KITITAS COUNTY

MEMORANDUM

SUBJECT: Bull Ranch LP-21-00001

A PORTION OF SECTION 12 T. 17 N., R. 18 E., W.M., KITTITAS COUNTY, WASHINGTON

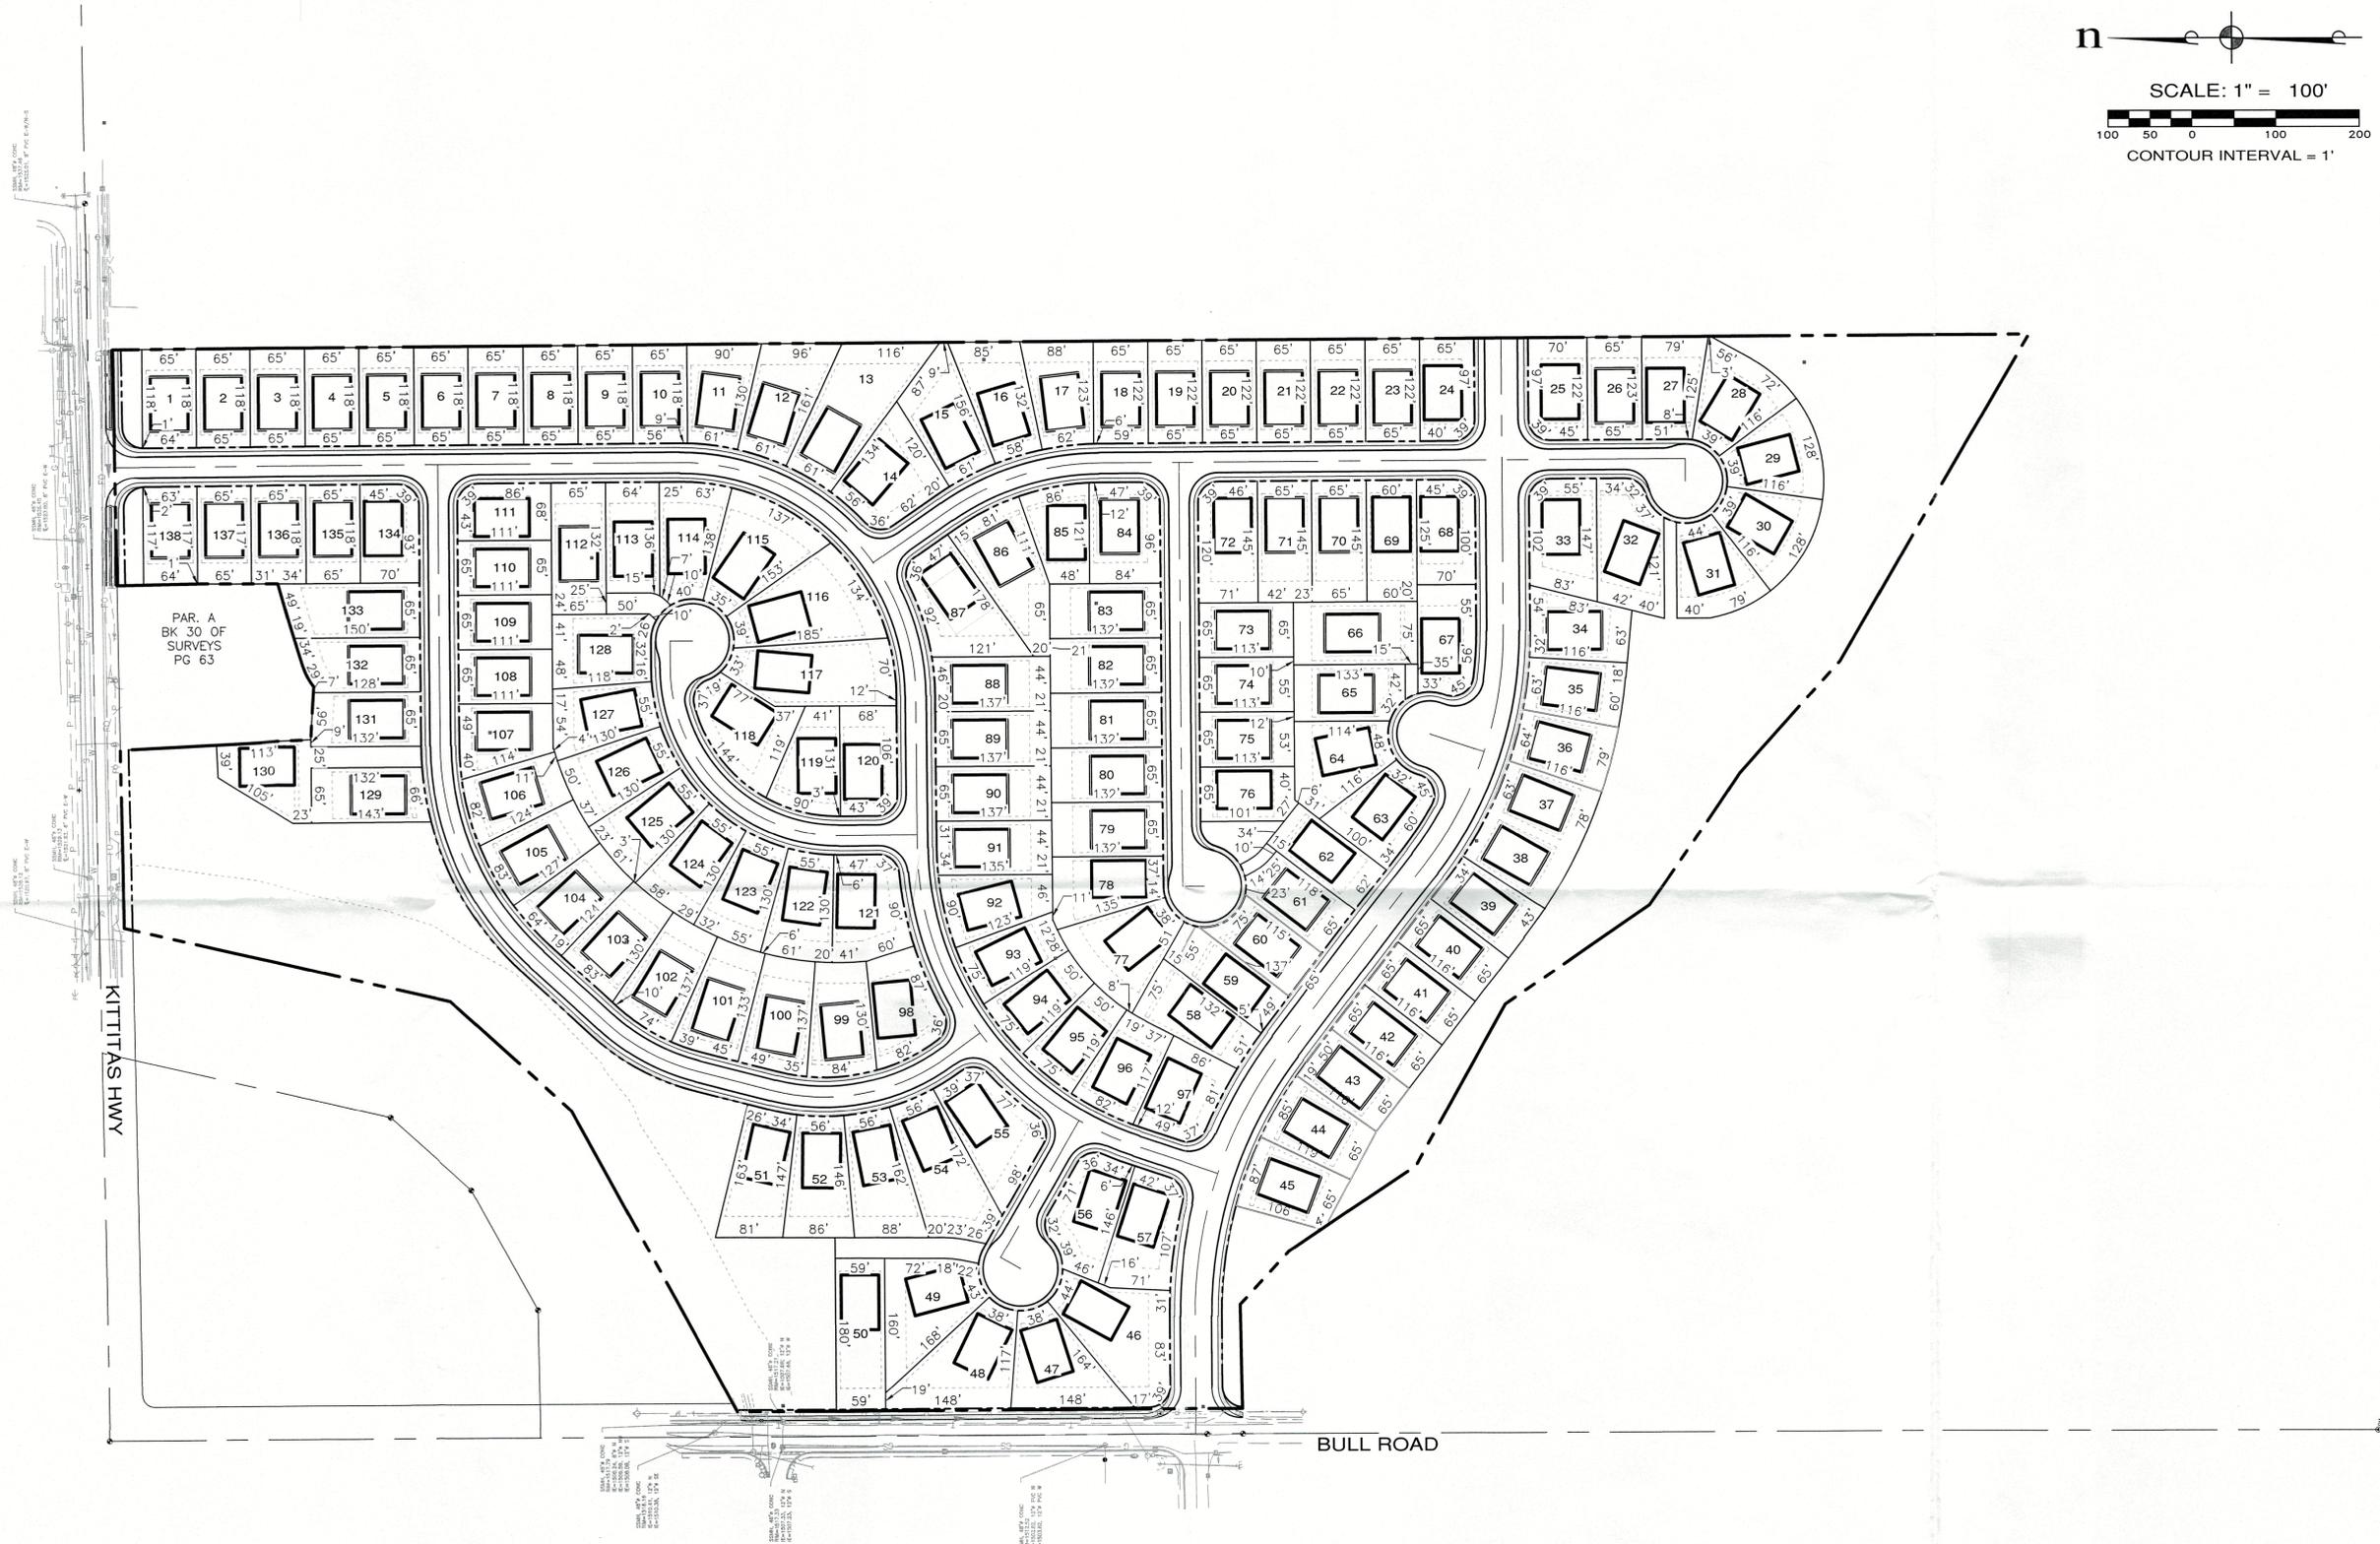
Kittitas County Code 16.24.010 requires that the Preliminary Plat submittals be prepared by a Licensed Land Surveyor. Under State Law, plans may be dual stamped as long as the division of responsibility is clearly defined. Please resubmit the documents with a surveyor stamp.

1. Plan set is missing some important road design information (curve radii, material type and thickness, utility infrastructure). The applicant should know that all Public Roads are subject to KCC Chapter 12.4. The applicant should submit full civil plans to both Kittitas County and The City of Ellensburg for review when the plan set is finished.
2. The applicant should know that conveyance analysis should be done before final plat is approved.

3. The applicant should know that a time series verifying that the infiltration ponds drain within 72 hours of a given storm event should be included before final plat is approved.
4. Offset intersections are not recommended. Please revise to not have an offset from the existing intersection. If not possible, left turn storage on Kittitas Highway needs to be maintained from Magnolia Street and created for the proposed street connection.
